Proposed New K-12 Educational Establishment

BLESSED CARLO CATHOLIC COLLEGE

Corner of Lignum Road and Kiely Road, Moama

The table below summarises comments received from the State Design Review Panel (SDRP) and resultant response incorporated into the final design for the proposed new Catholic school.

Drawing
SHADOW DIAGRAMS

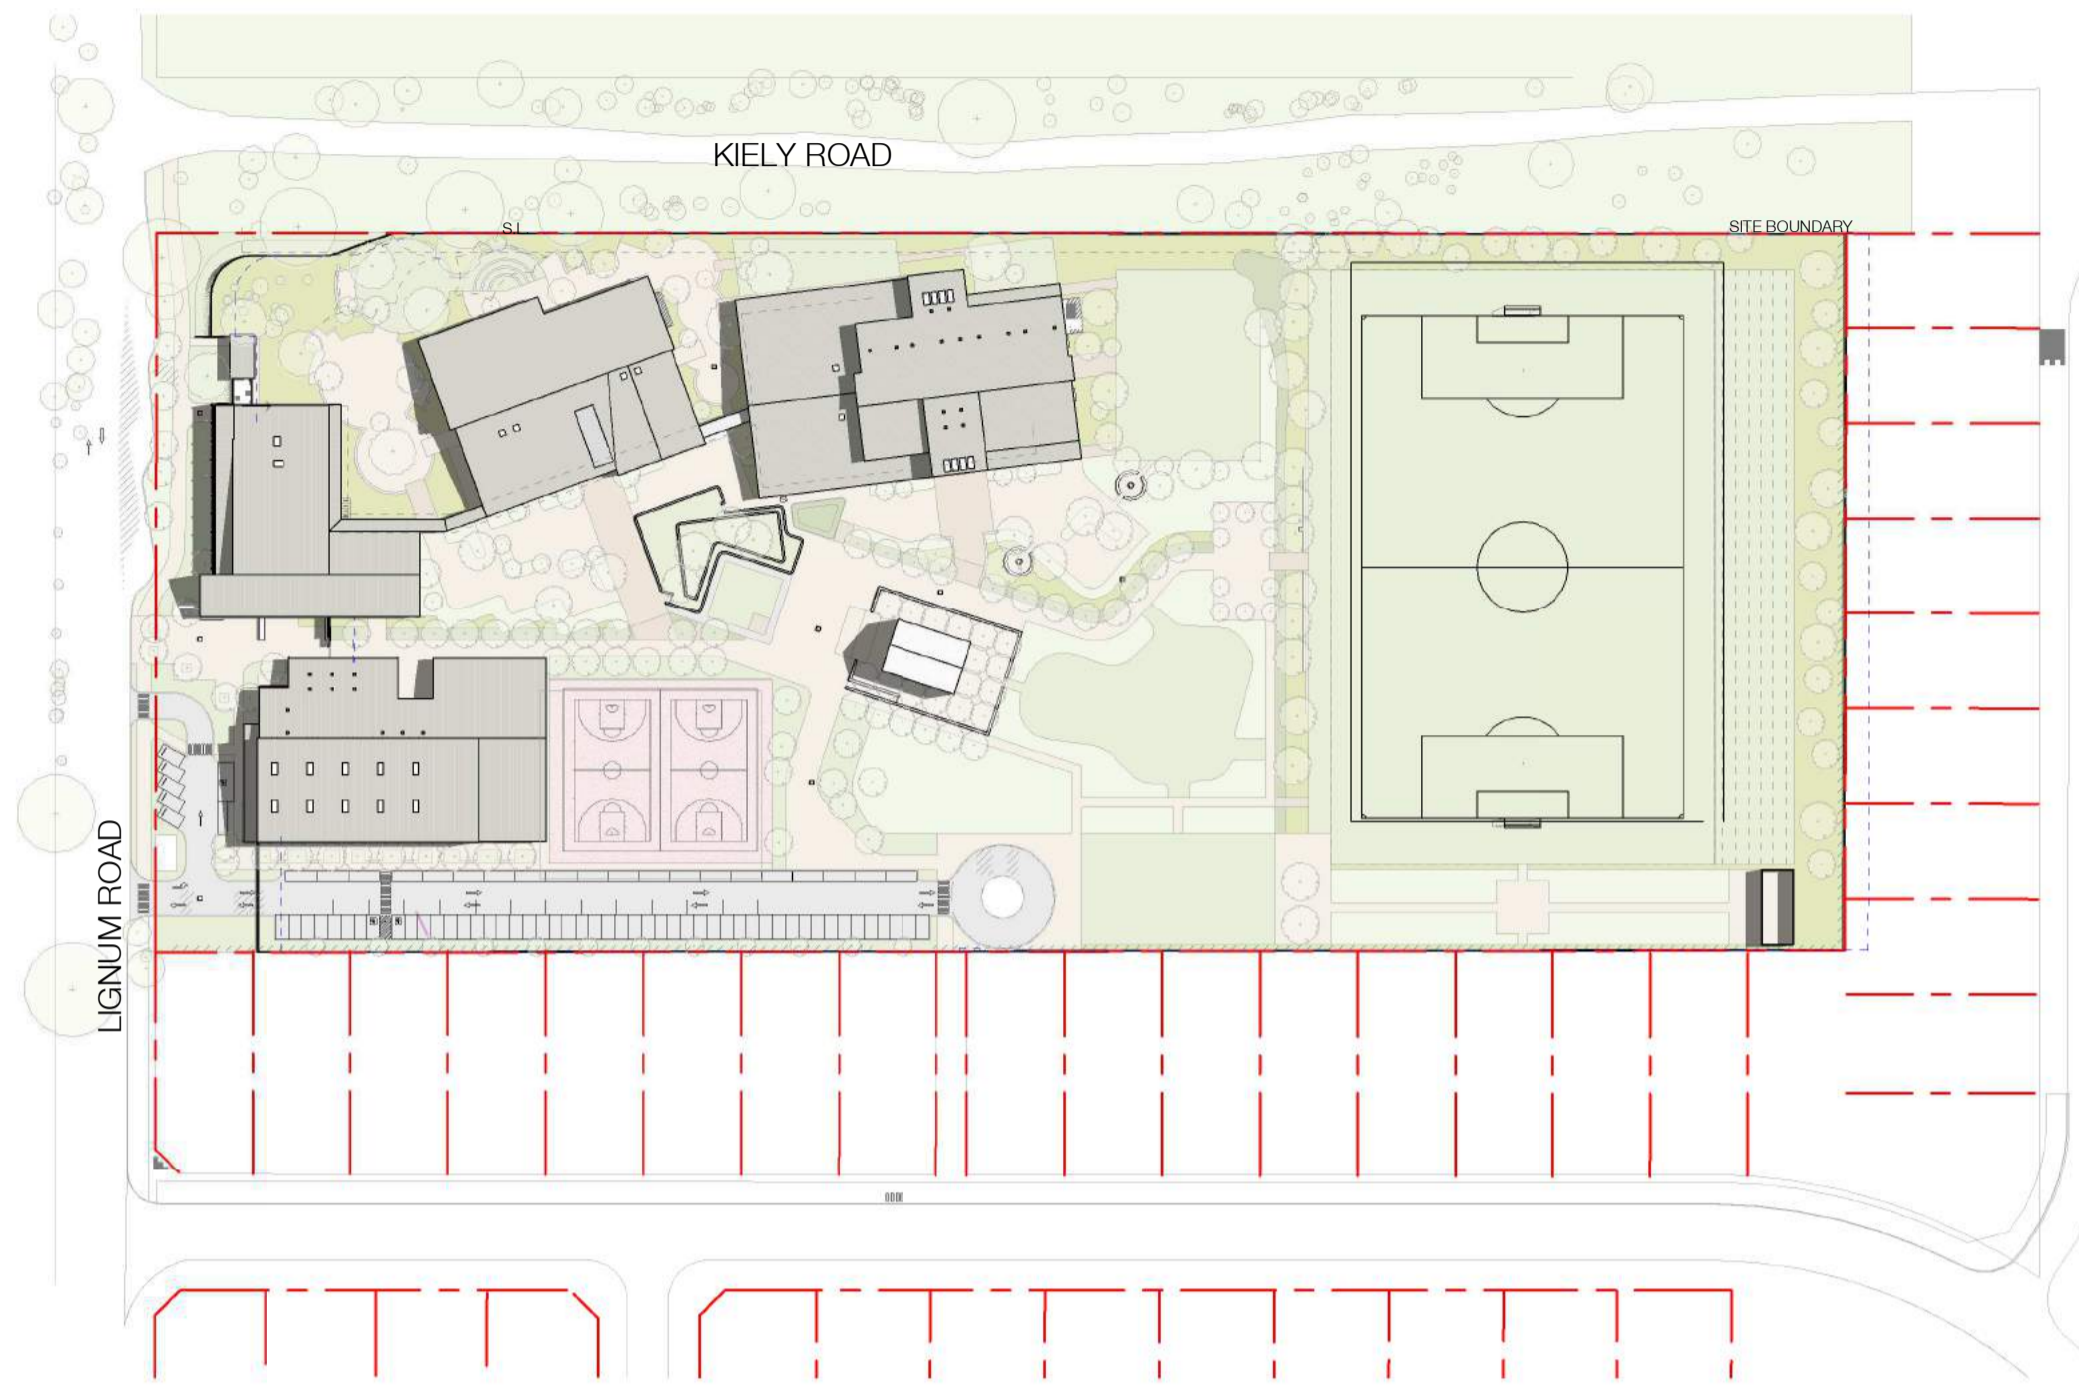
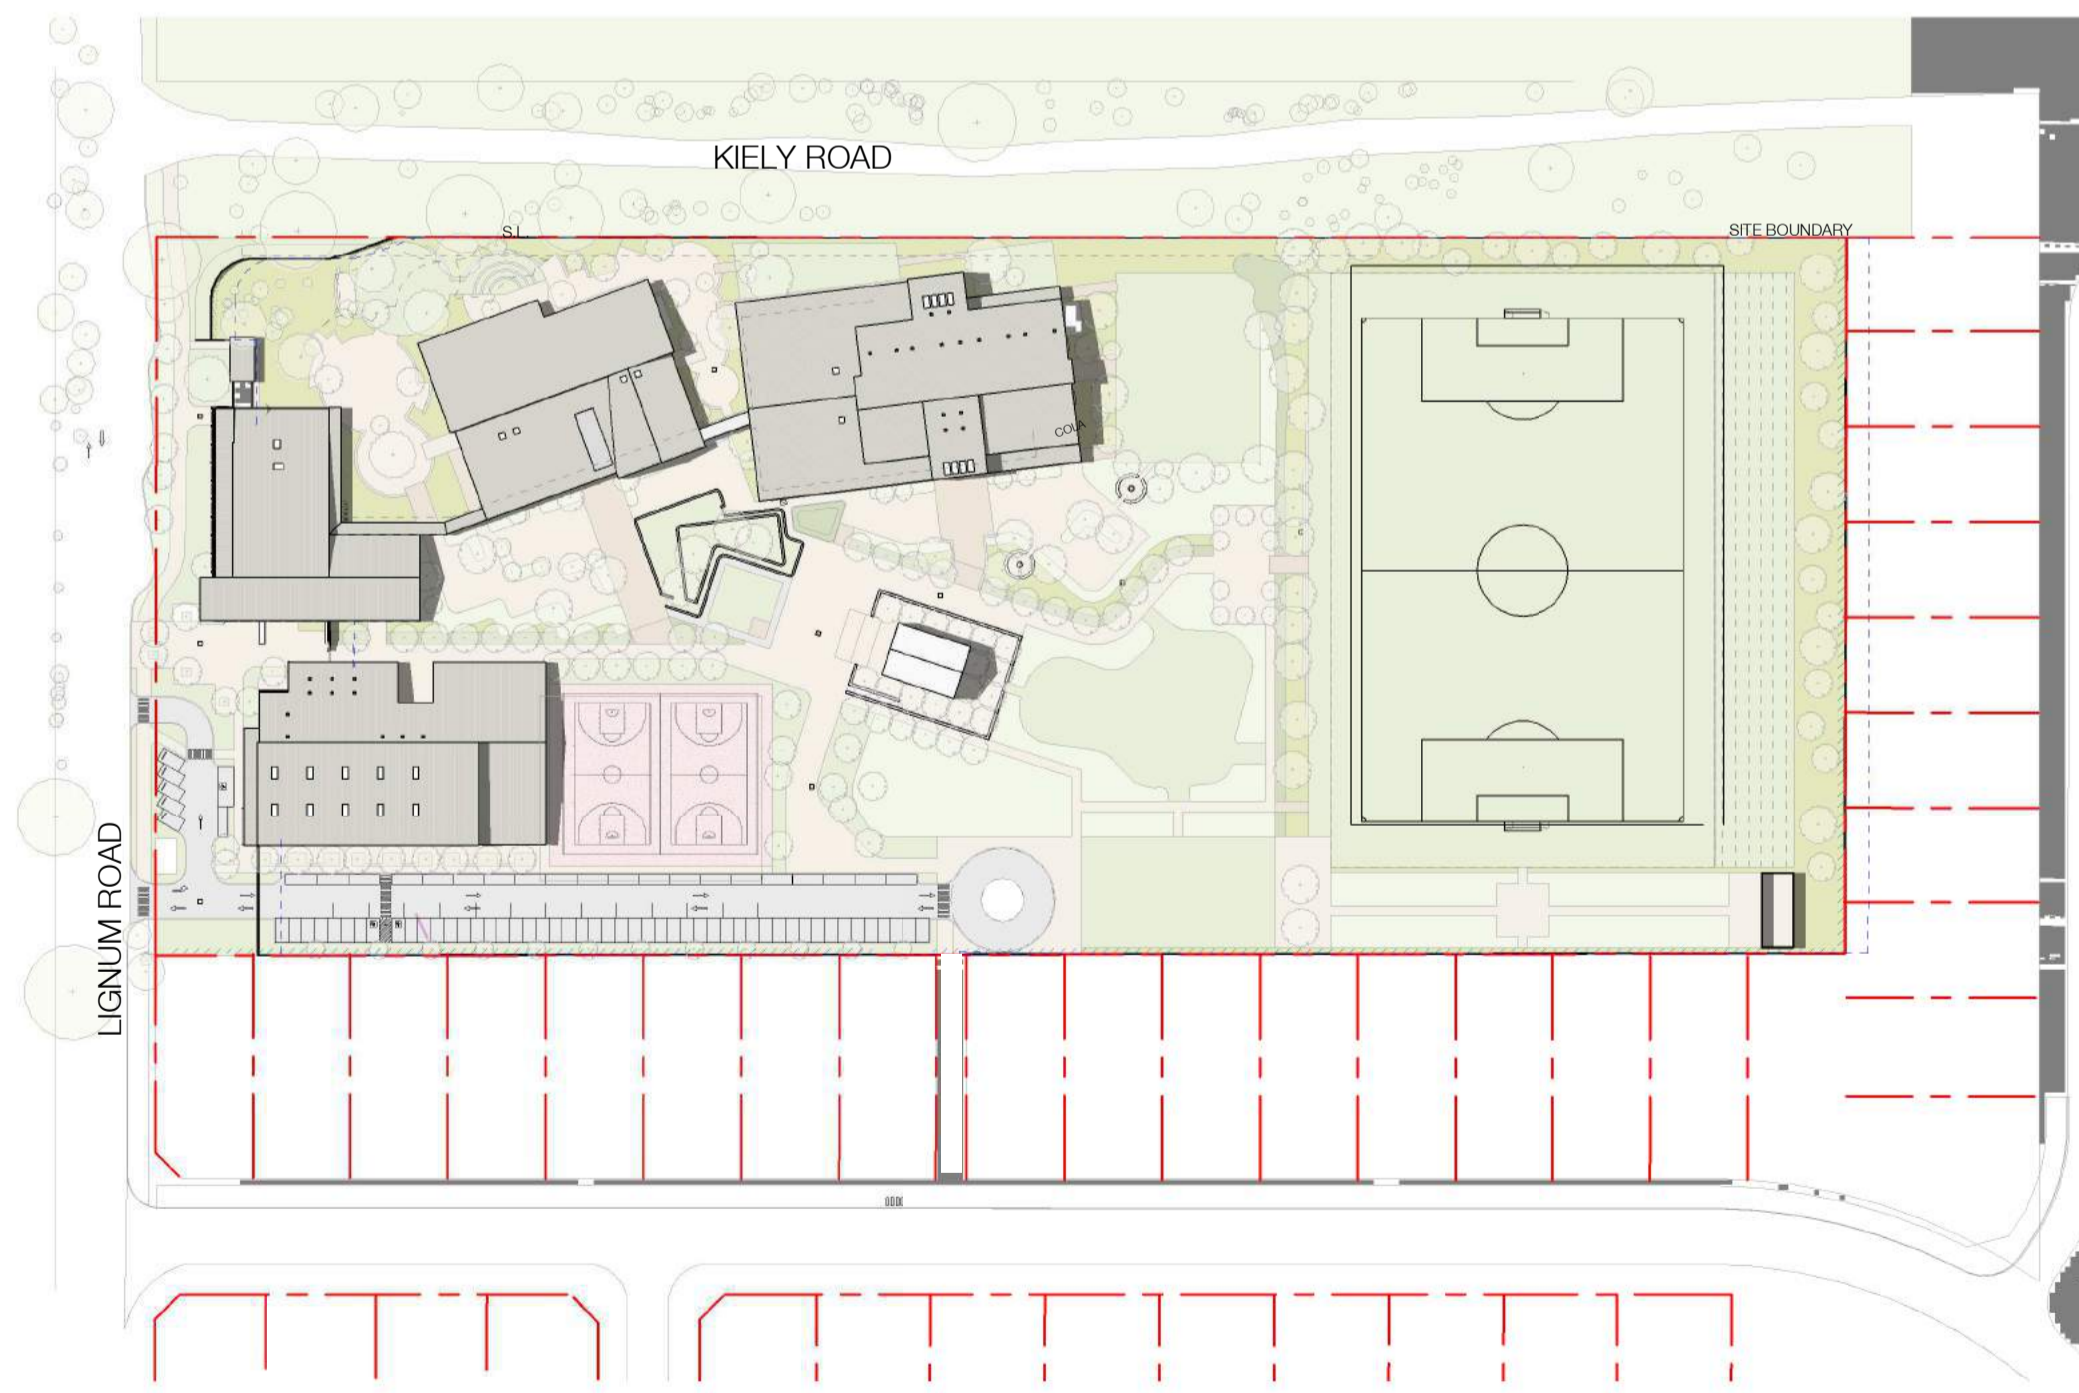
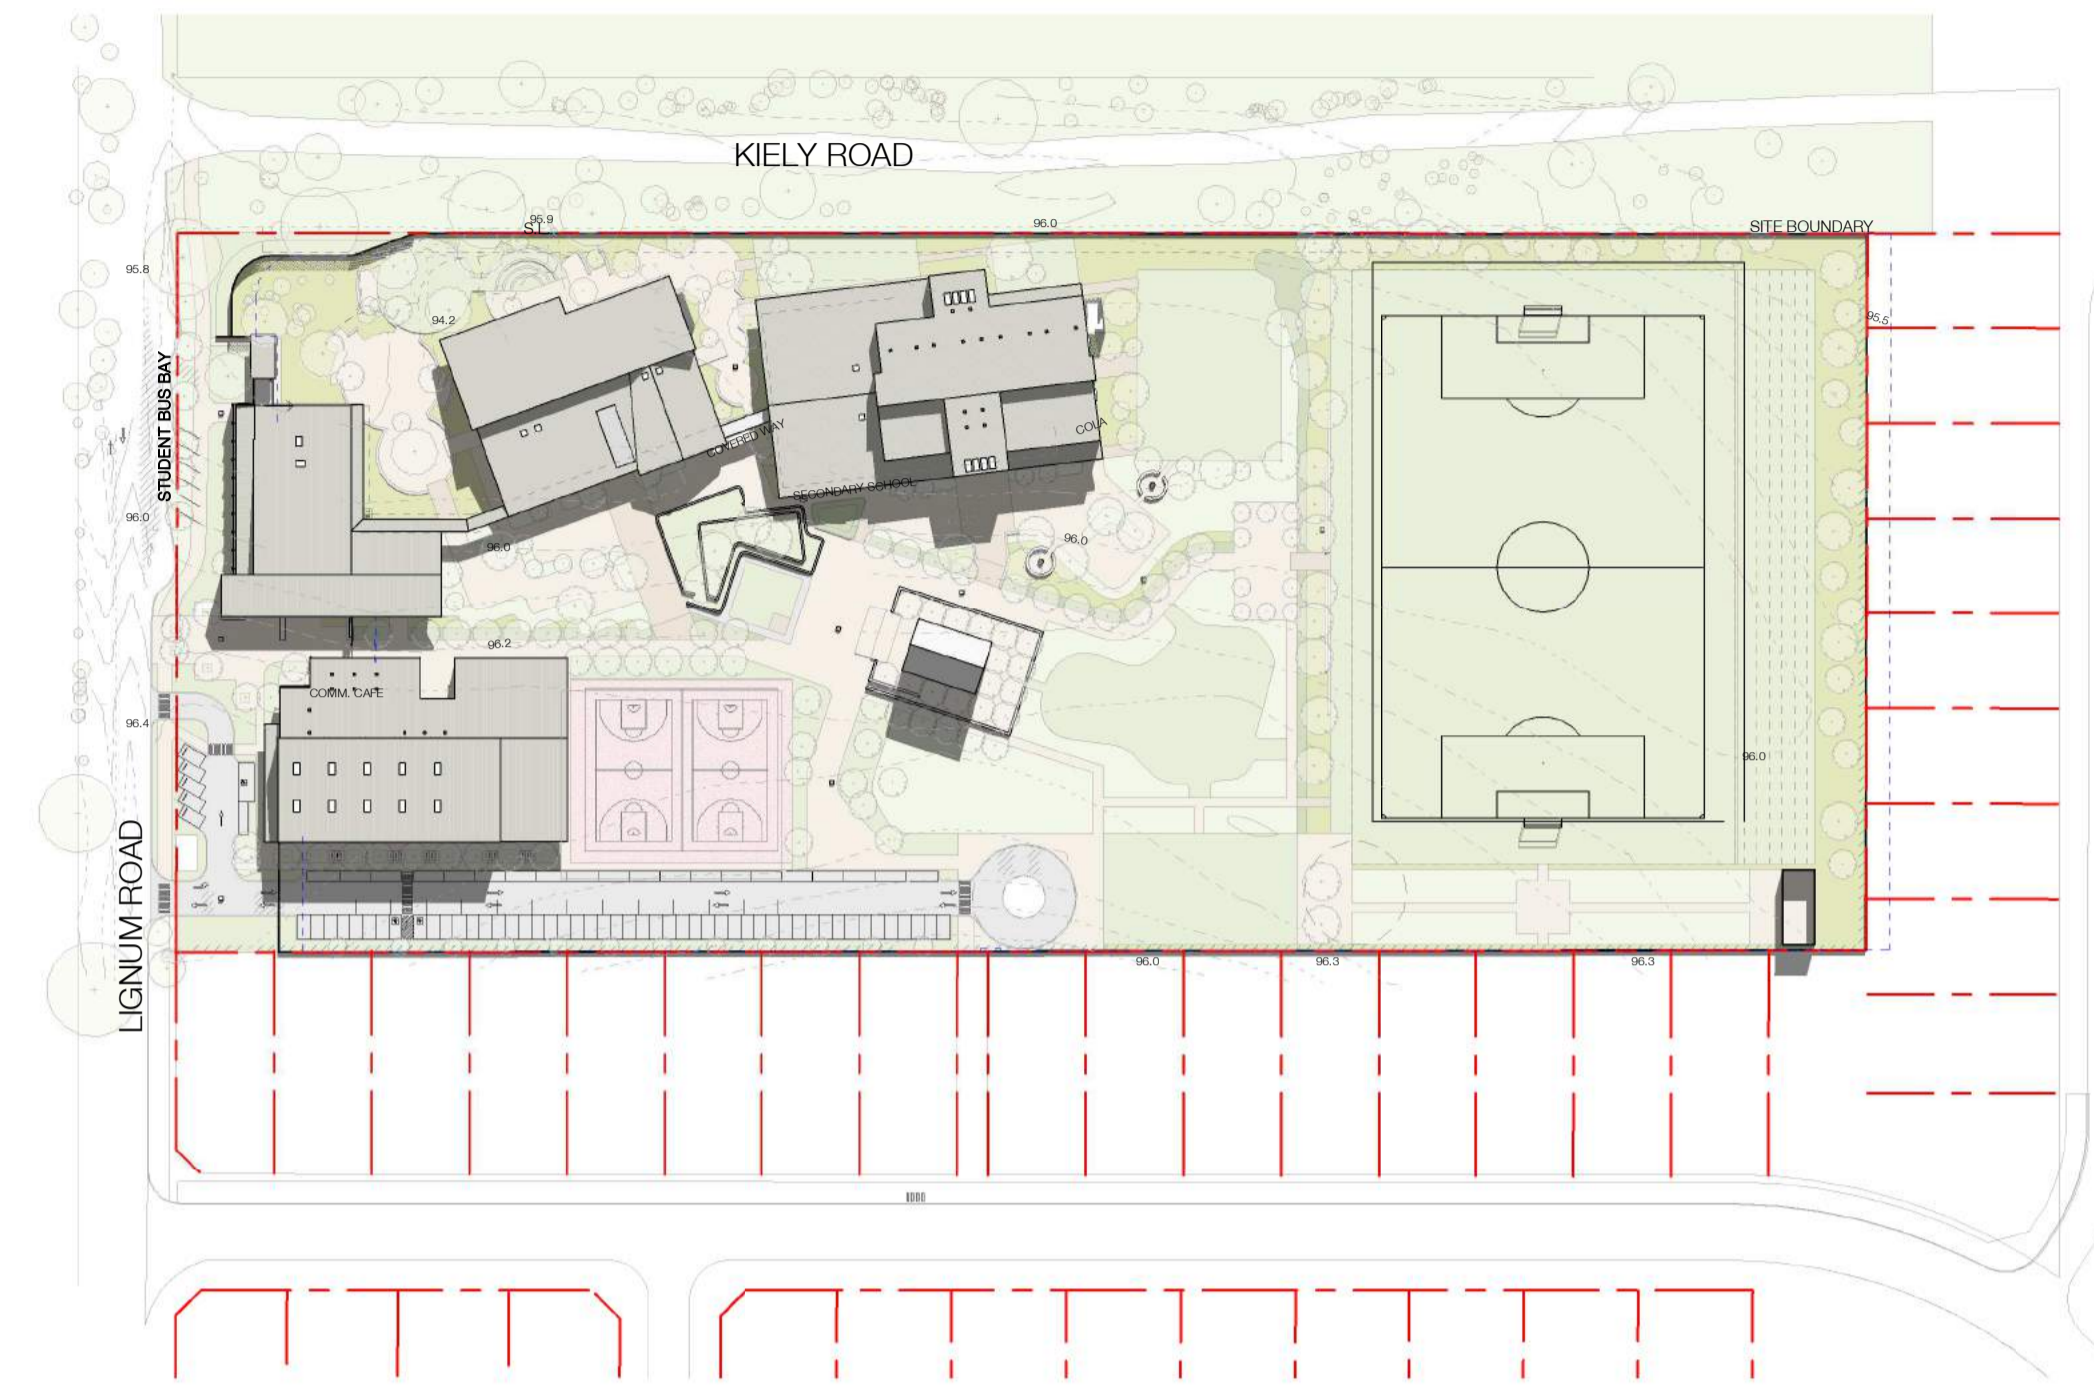
Northern edge of site appears to encroach on Council land, provide evidence this has been discussed with Council.	Satisfied, discussions with Murray River Council included in EIS.
Architecture	
Provide evidence of good sunlight access in interior spaces to support learning, comfort, and environmental demands.	Satisfied, provided in Architectural Plan Set.
Detailing and scale of colonnade requires further development.	Satisfied, provided in Architectural Plan Set.
Sustainability and Climate Change	
Develop a clearer sustainability strategy for design and how it is integrated into environmental and energy systems.	Satisfied, provided in Architectural Plan Set and Architectural Design Statement.
Envision project as opportunity to embody principles set out in Pope Francis' encyclical <i>Laudato Si</i> , demonstrating the school's commitment to caring for the environment through pedagogy and built assets.	Satisfied, considered during design development. See final Architectural Report.
